RE: LAND SOUTH OF SOUTH SIDE, STEEPLE ASTON.

Further to the grant of planning permission (Ref: P19/02948/F) at the above site, please find enclosed an application made by Rectory Homes seeking a minor-material amendment to the approved plans for the site. The application has been submitted via the Planning Portal (ref: PP-09988277).

Rectory Homes are seeking approval of a minor-material amendment application to make a number of design changes to plots 1, 2, 3, 4, 5, 6, 7 and 10. These changes are listed below:

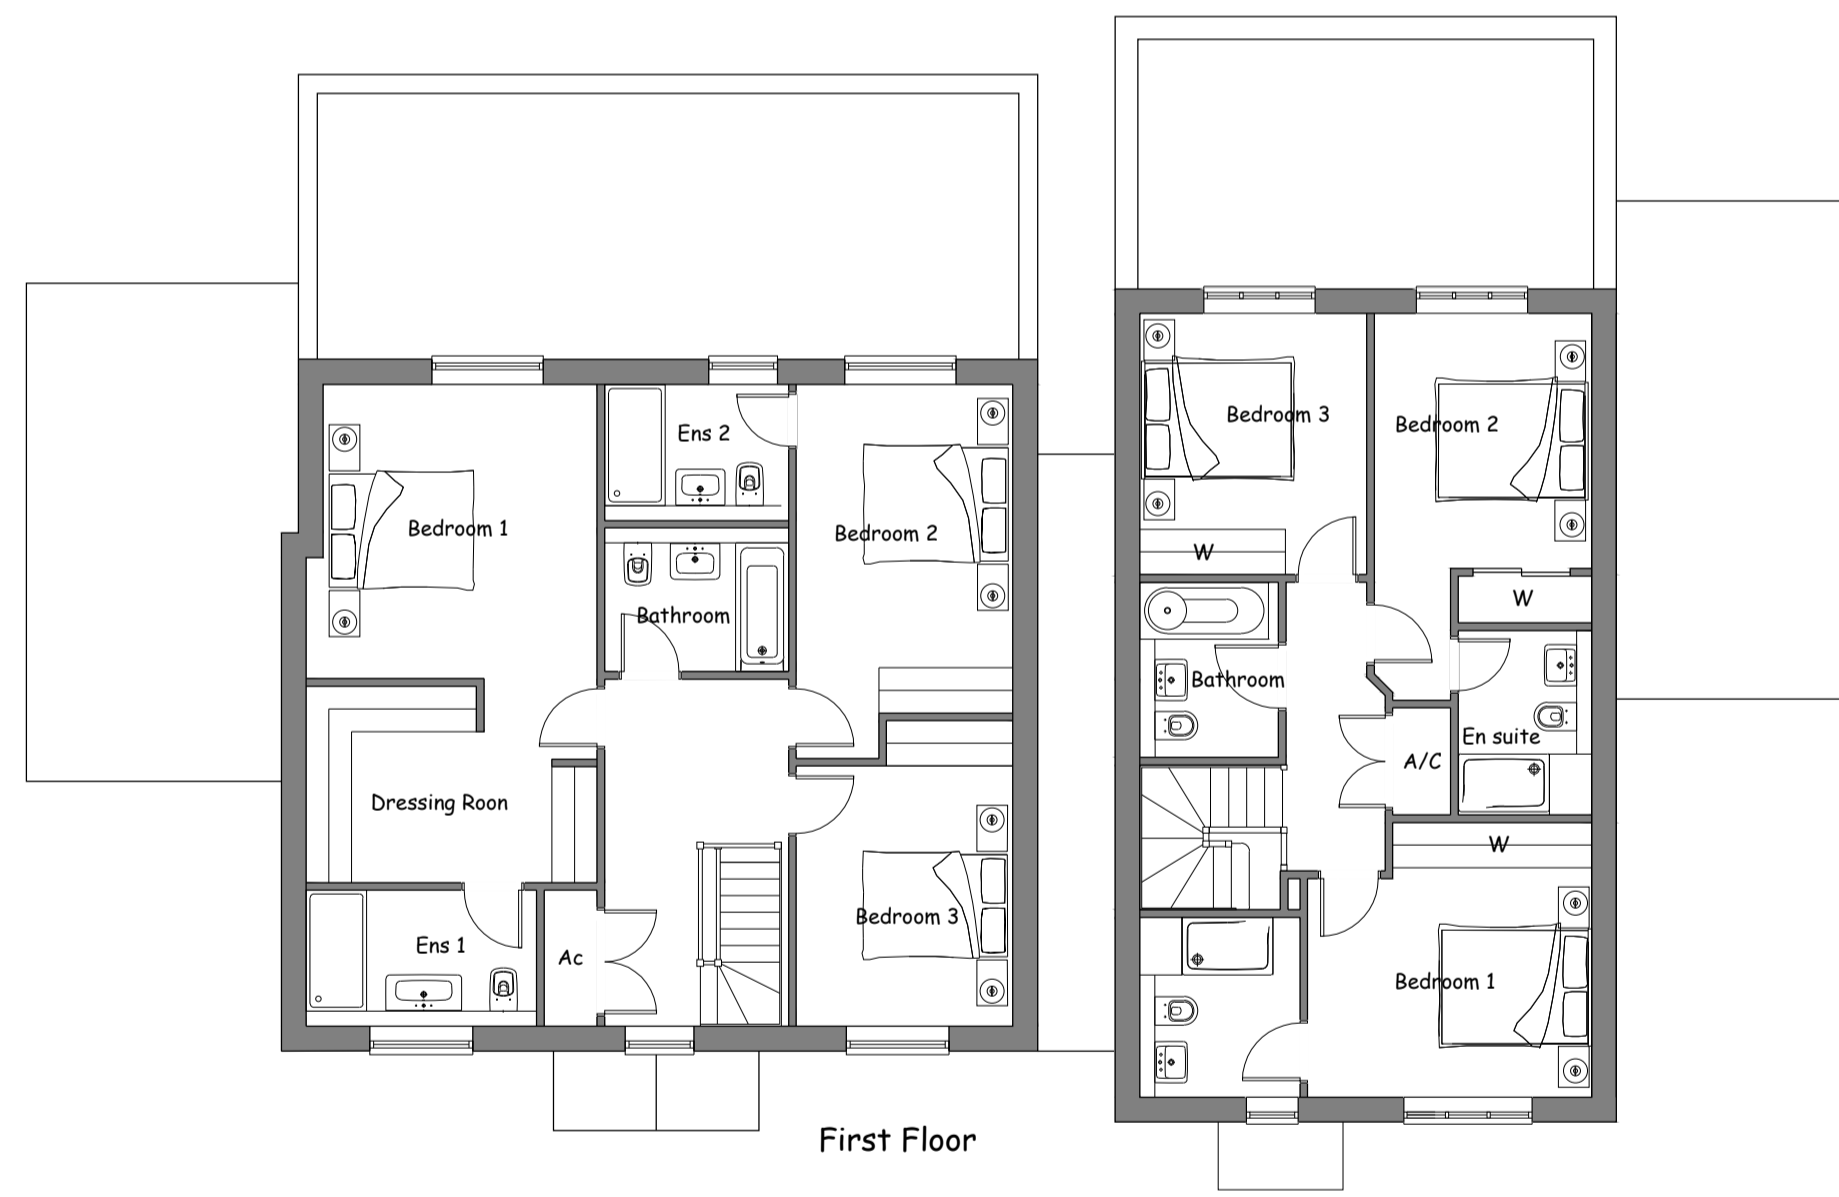
- **Plots 6 & 7:** Single storey rear extensions. Inclusion of home office and re-configuration of family room / dining room to plot 6. Extended kitchen / dining area / family room to plot 7;
